# CITY OF ALBUQUERQUE

Re: **COA-Westside Vehicle Maintenance/Office Bldg**  
**18000 Cerro Colorado Road SW**  
**Traffic Circulation Layout**  
Architect's Stamp 10-30-2020 (P01-D001A)

Based upon the information provided in your submittal received 10-30-2020, the above referenced plan cannot be approved for Building Permit until the following comments are addressed:

GRADING AND DRAINAGE PLAN
C-101
OF SHEET

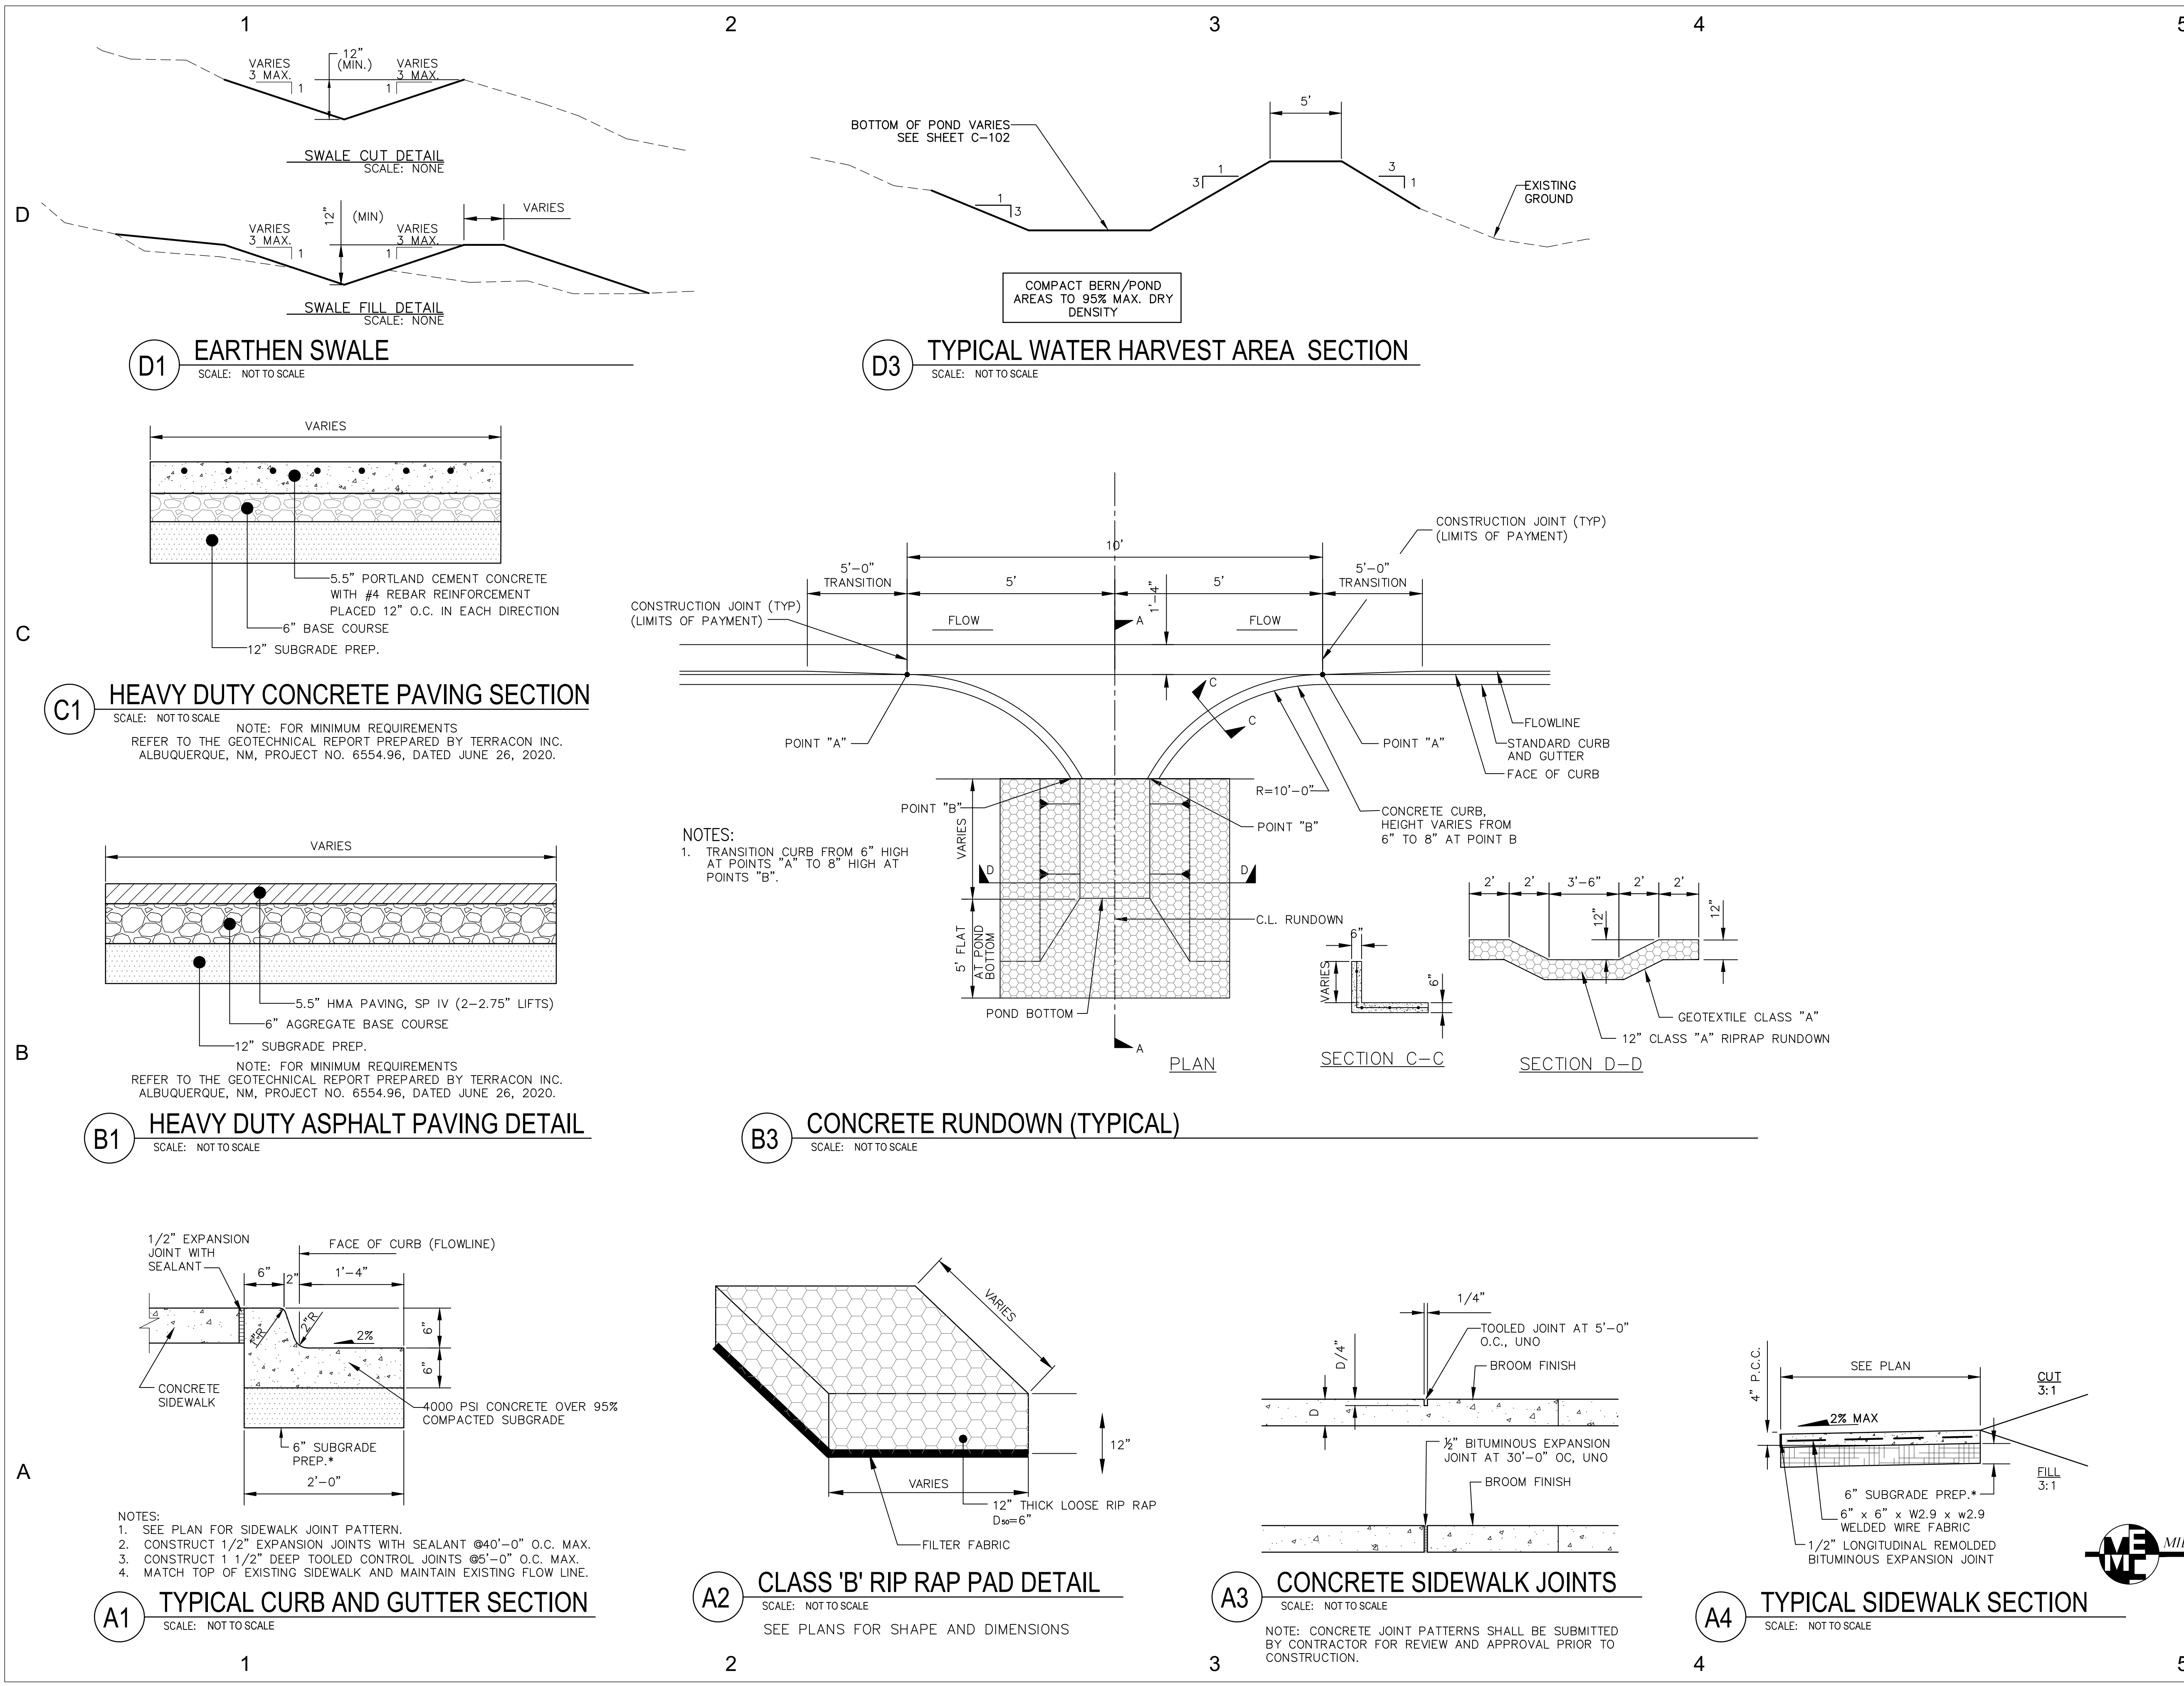
24. It is not apparent what type of pavement surface is being proposed. A hard driving surface will be required as part of this proposed project for parking area and drive aisles. **A detail will need to be provided.** ALL NEW HMA HEAVY DUTY PAVEMENT

SITE PLAN

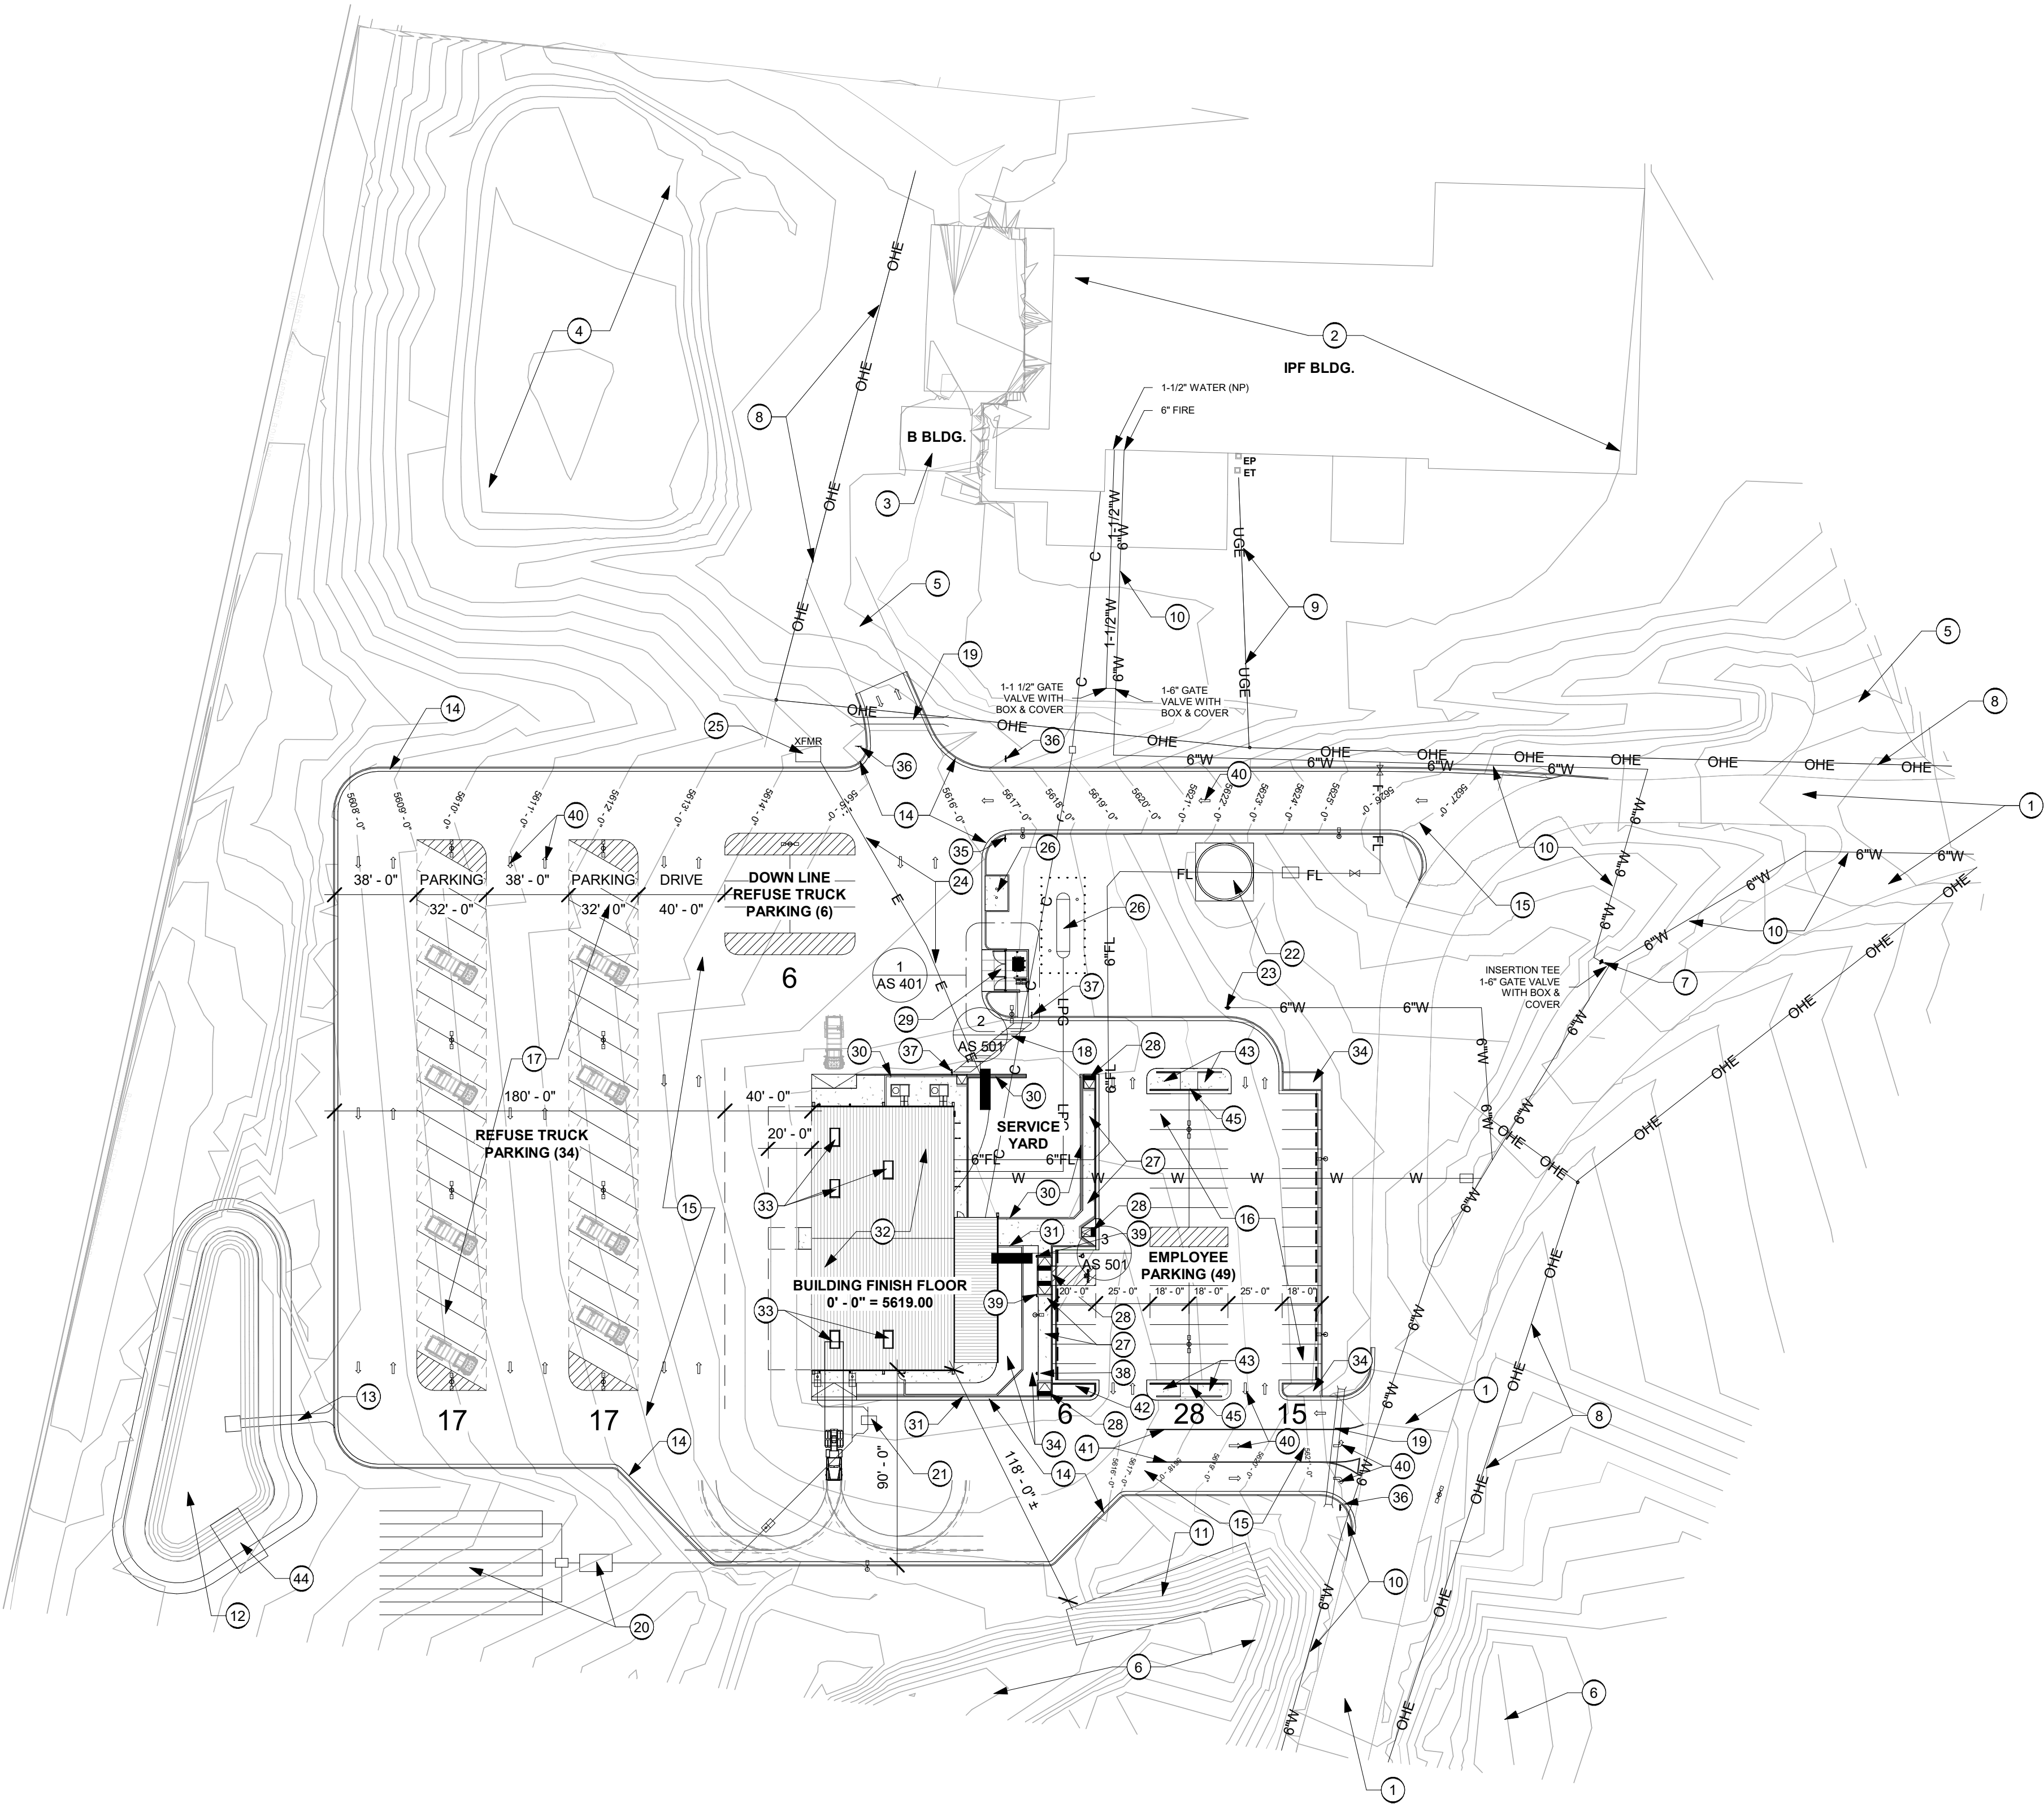
2. Site Plan: Please clean up sheet showing contour lines for your submitted TCL plan. ACKNOWLEDGE, THE TOPO LINES LAYER WILL BE TURNED OFF
3. Plat Status: Please provide an approved plat if the property was subdivided for this proposed site development. NOT APPLICABLE, THIS IS 6 ACRES WITHIN 870 ACRE OPERATIONAL AREA

7. Please list the width and length for all existing and proposed parking spaces. Some dimensions are not shown. ADD DIMENSIONS
8. The minimum parking stall dimensions are: ACKNOWLEDGED, SPACE SIZES WILL BE REVIEWED AS STATED AND CORRECTED IF REQUIRED

Show all drive aisle widths and radii. Some are not shown.

List radii for all curves shown; for passenger vehicles. **Radius for delivery trucks, fire trucks, etc. is 25 ft. or larger.**

Per DPM, a 6 ft. wide ADA accessible pedestrian pathway is required from the ADA parking stall access aisles to the building entrances. Please clearly show this pathway and provide details.

21. Curbing should be installed to delineate landscape, parking, and pedestrian ways and identify points of access. **Please call out detail and location of barrier curb.** PERIMETER OF POV PARKING AREAS @ SIDEWALKS TO ENTRANCE, PERIMETER OF ALL SITE PAVING AREAS

26. Show the clear sight triangle and add the following note to the plan: REFLECT SIGHT TRIANGLE
